20 March 2017

Cameron Sargeant, Team Leader, Key Sites Assessments
NSW Department of Planning and Environment
Sydney NSW 2000

State Significant Development Application SSD 7246: Foreshore and Public Domain Works at Campbell's Cove, The Rocks

LANDSCAPE DETAILS - PAVING & EDGE DETAIL
1 OF 3

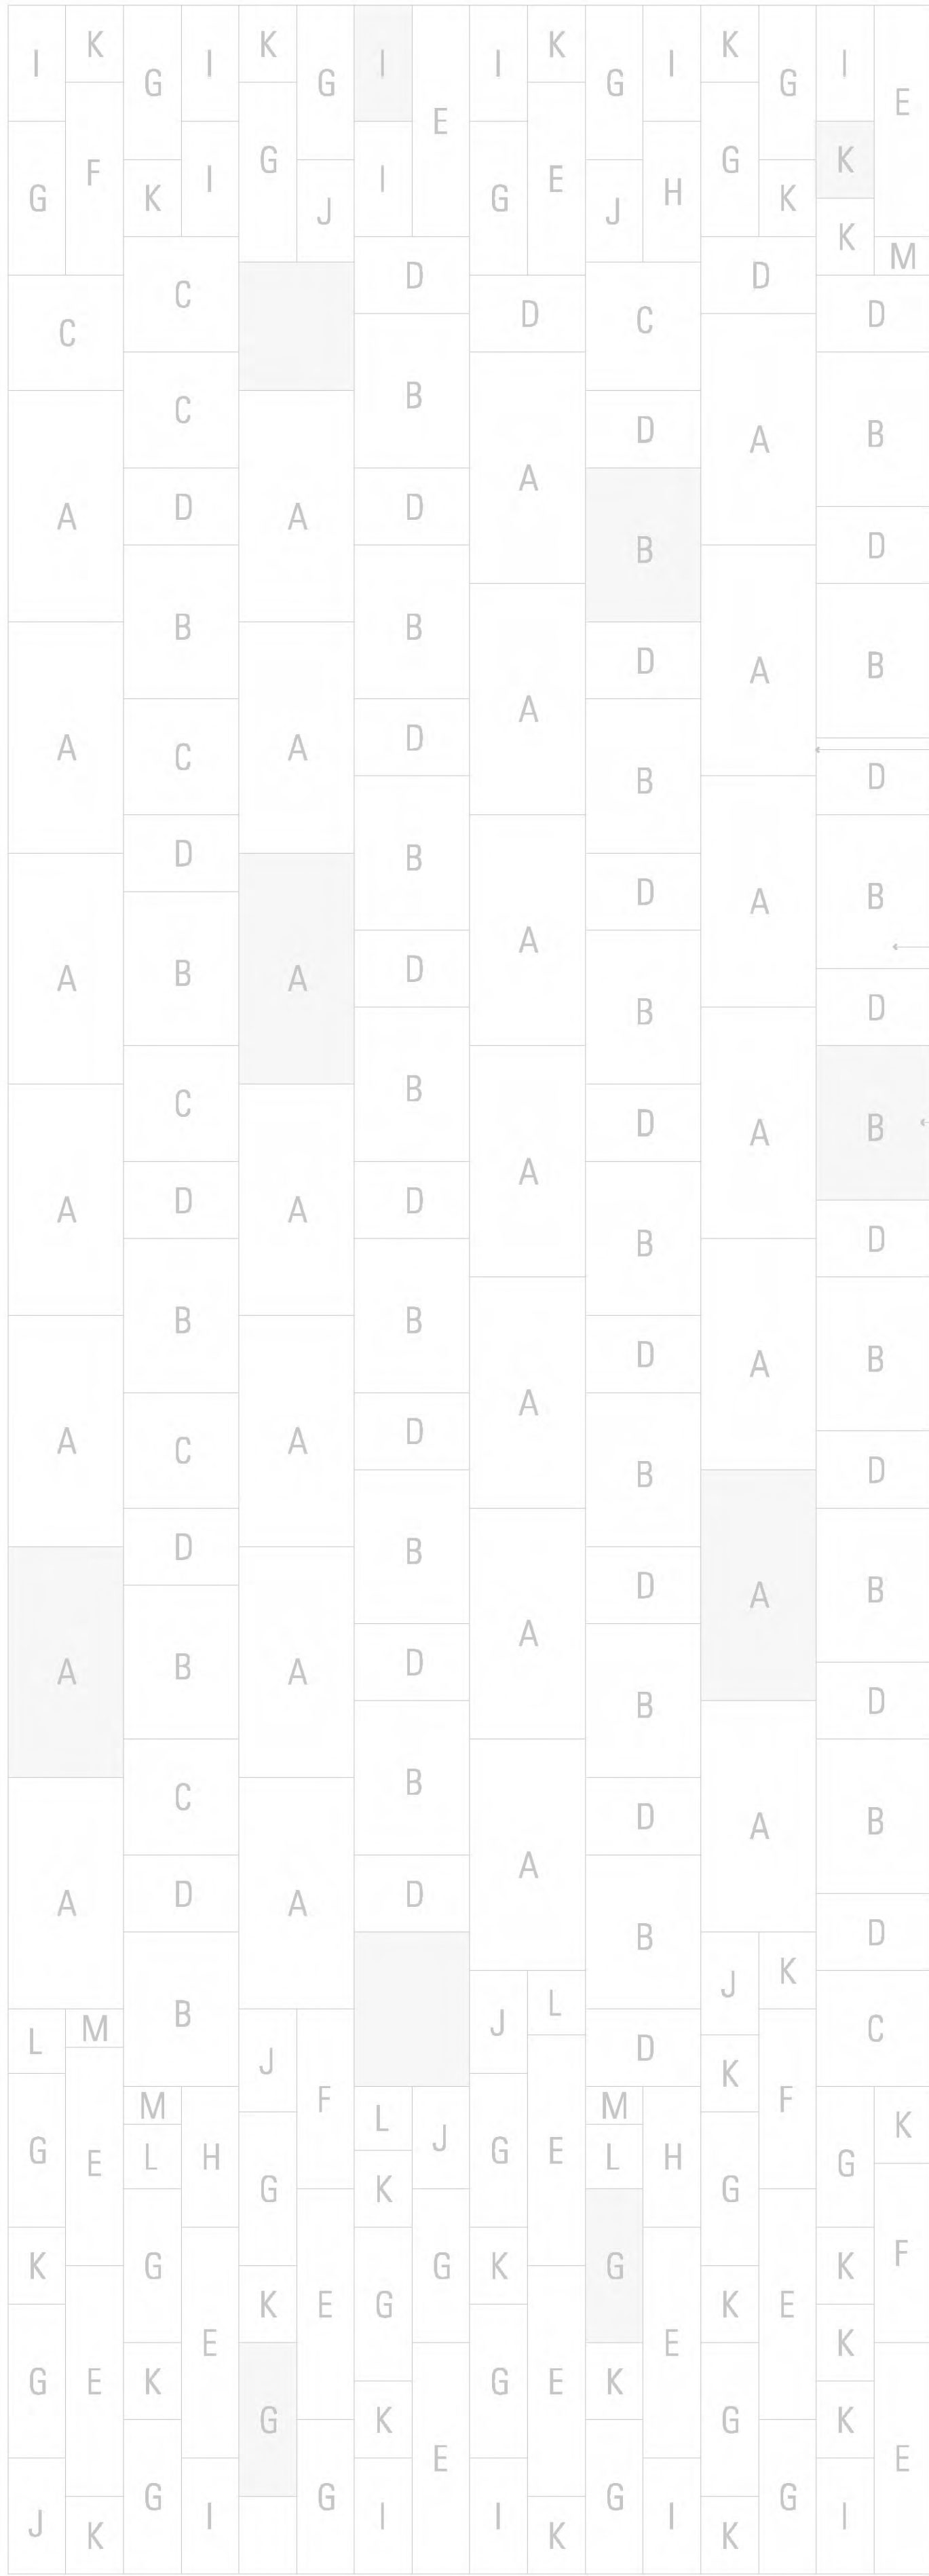
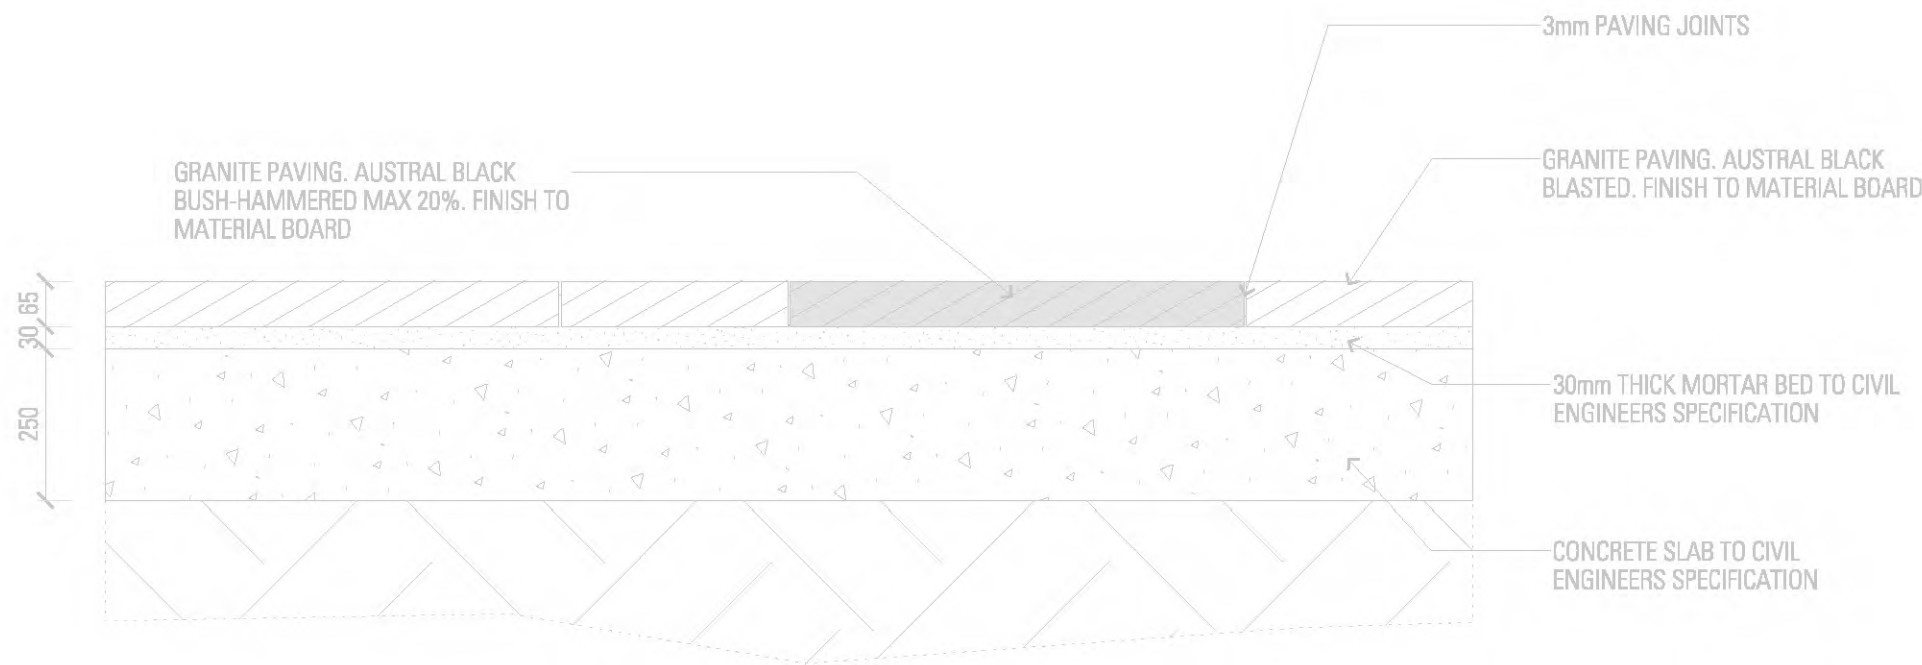
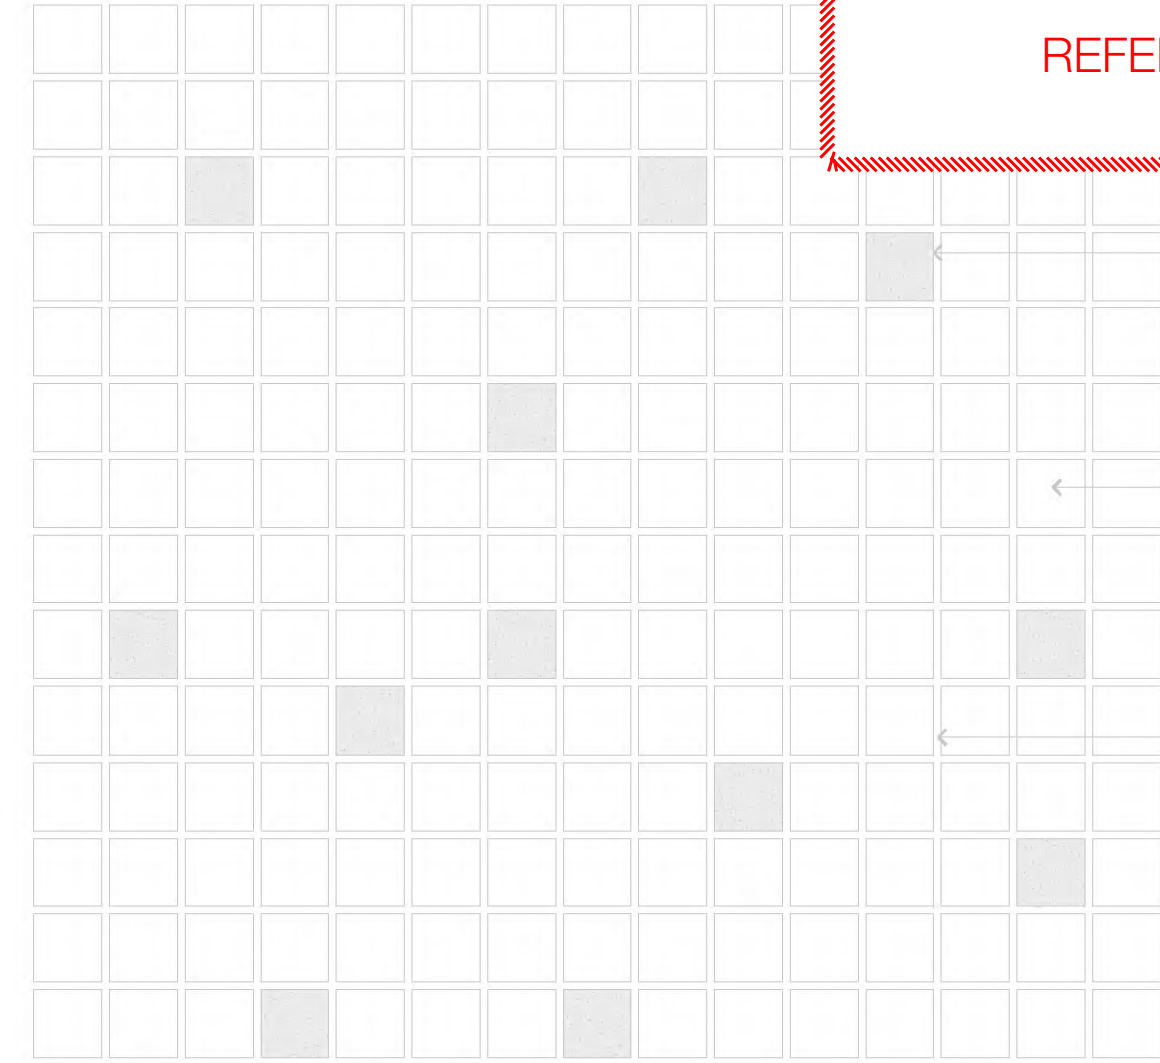
Campbell's Cove has a unique architectural character different to the rest of Circular Quay and could be treated as a special precinct with complementary public domain materials. Due to the heritage significance of the locality, granite may not be appropriate as the predominant finish in this particular area.

In light of the above, while the City considers it acceptable to have a predominantly granite finish around Circular Quay, inflections in the paving of a different colour/texture, should be used to highlight special moments around the Quay, such as this location. Customs House Square is an example of where inflections in the standard city palette have been used to reflect the special nature of the place. It is recommended that inflections at Campbell's Cove could be of a warmer tone to complement the sandstone heritage buildings.
